From: Amanda Scholes on behalf of Planning.Responses
Sent: 11 October 2017 10:33
To: Planning Scanning
Subject: FW: Planning Consultation on: FG/151/17/DOC

APPLICATION NO: FG/151/17/DOC

Site Address: Ferring Country Centre and Riding Stables Rife Way Ferring BN12 5JZ

Description of Works: Application for approval of matters reserved by condition imposed under FG/129/16/PL relating to condition 3 for surface water drainage.

PROPOSED BLOCK/SITE PLAN - 1:250

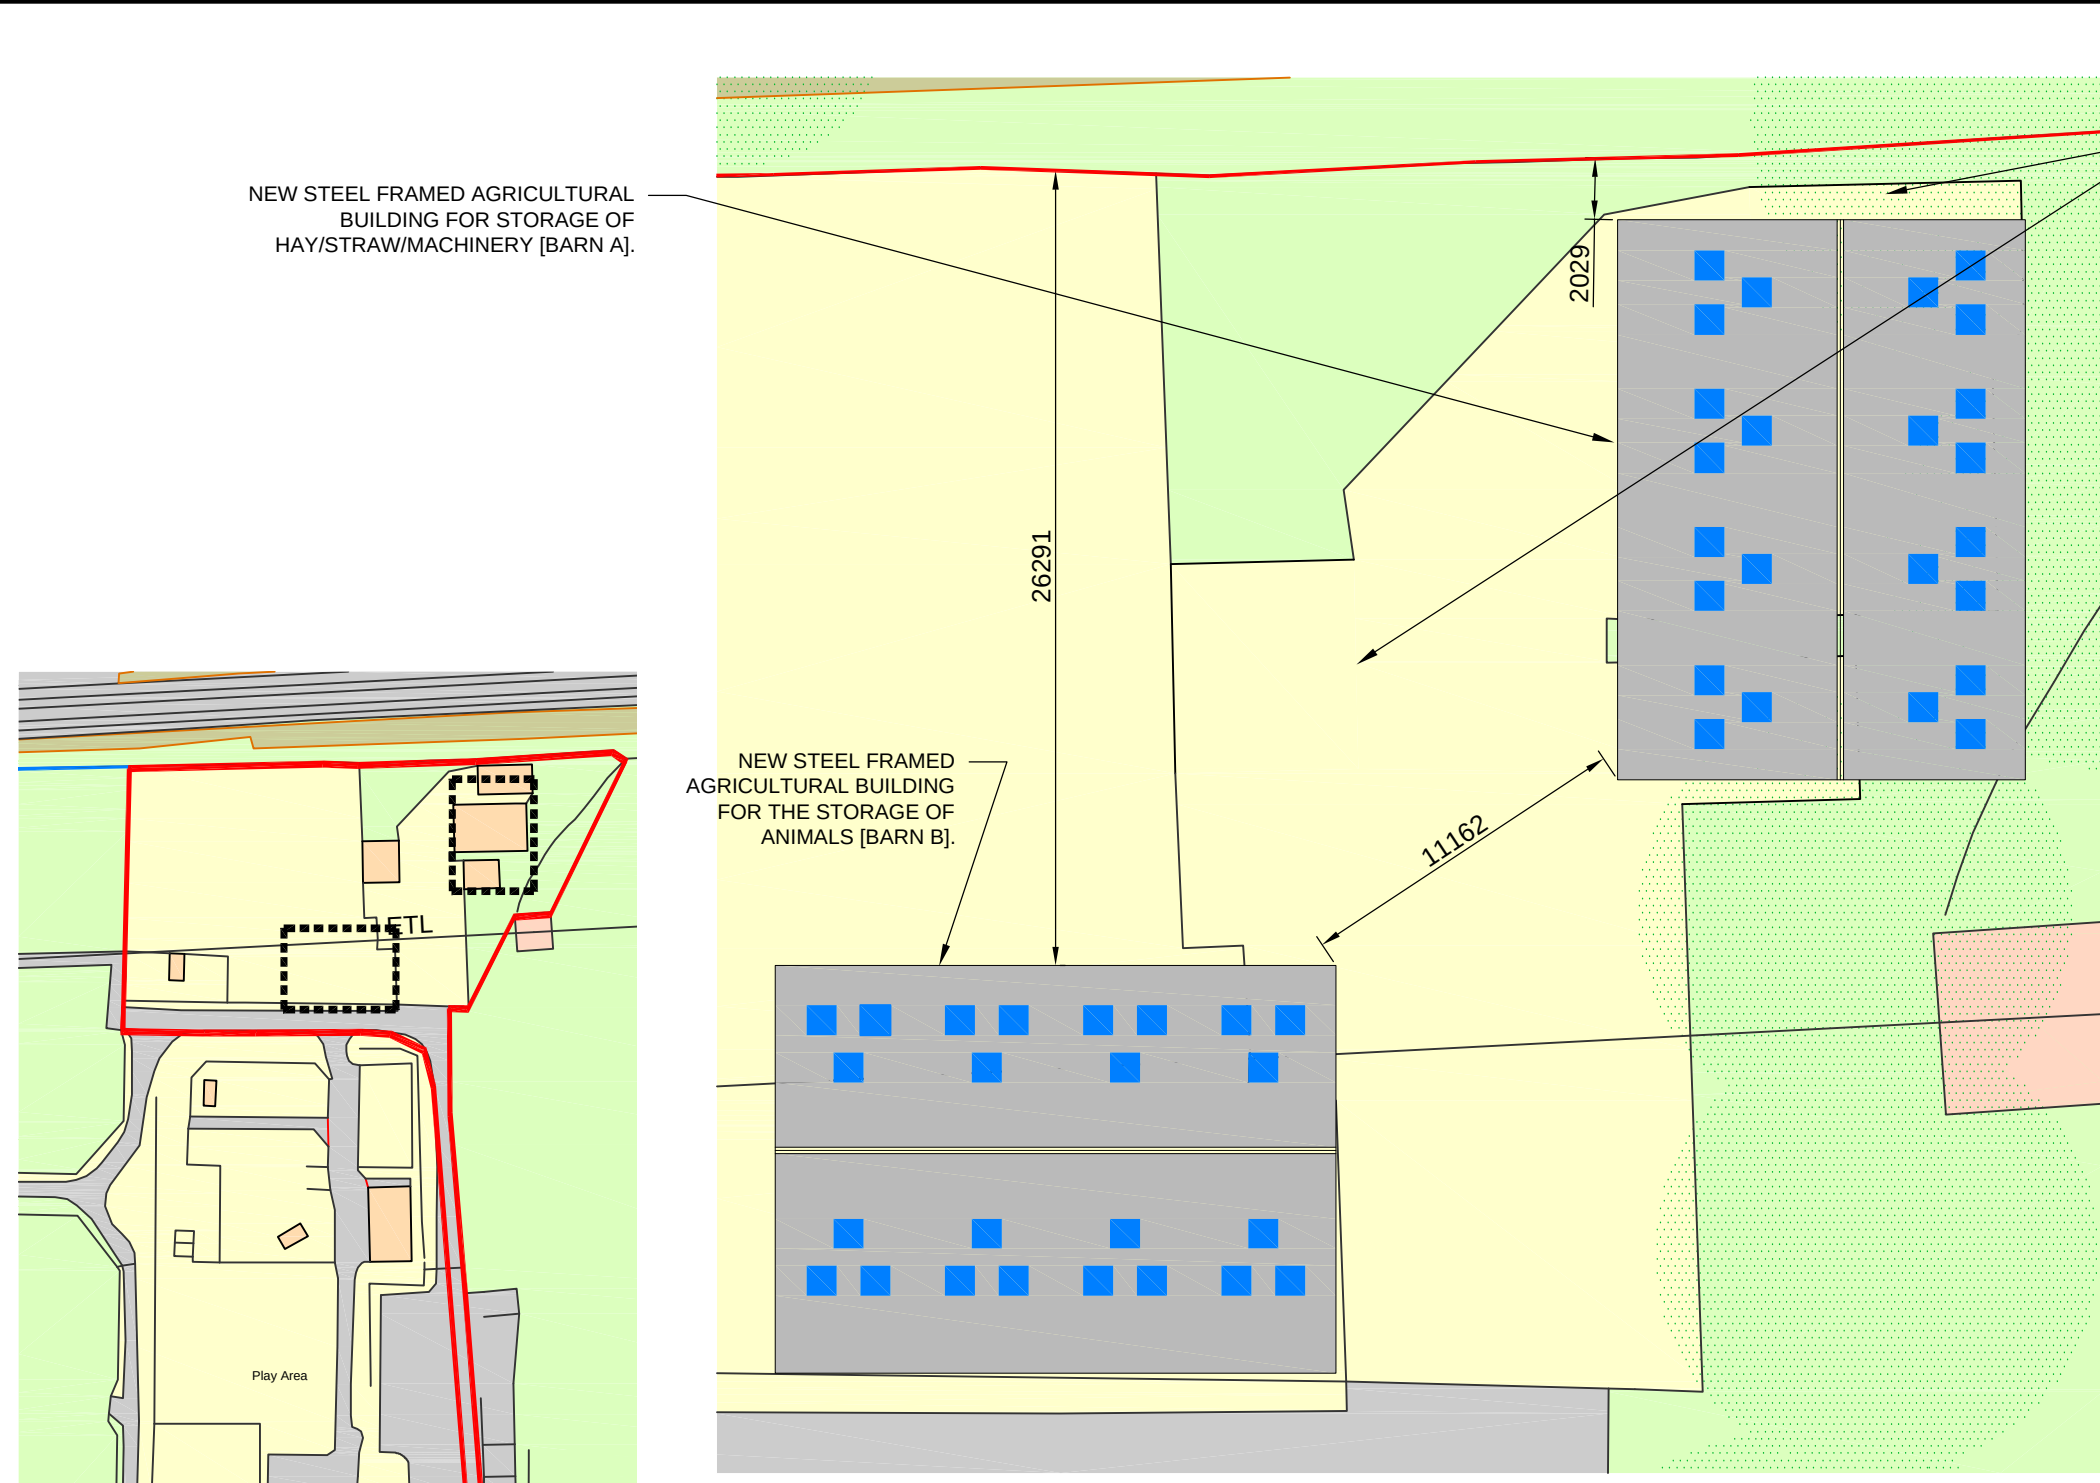
1. Winter groundwater data (peak) to ensure no loss of storage within the basin or plate soakaway.
2. Full details of the winter percolation testing to BRE365. I note 1×10^{-6} m/s has been used for the calculations.
3. Fully detailed drainage layout including levels.
4. Detailed construction details of all drainage elements, including the catchpit manholes. Plate soakaway beneath concrete pavement to have type 3 stone wrapped (sides/base) in a permeable geotextile.
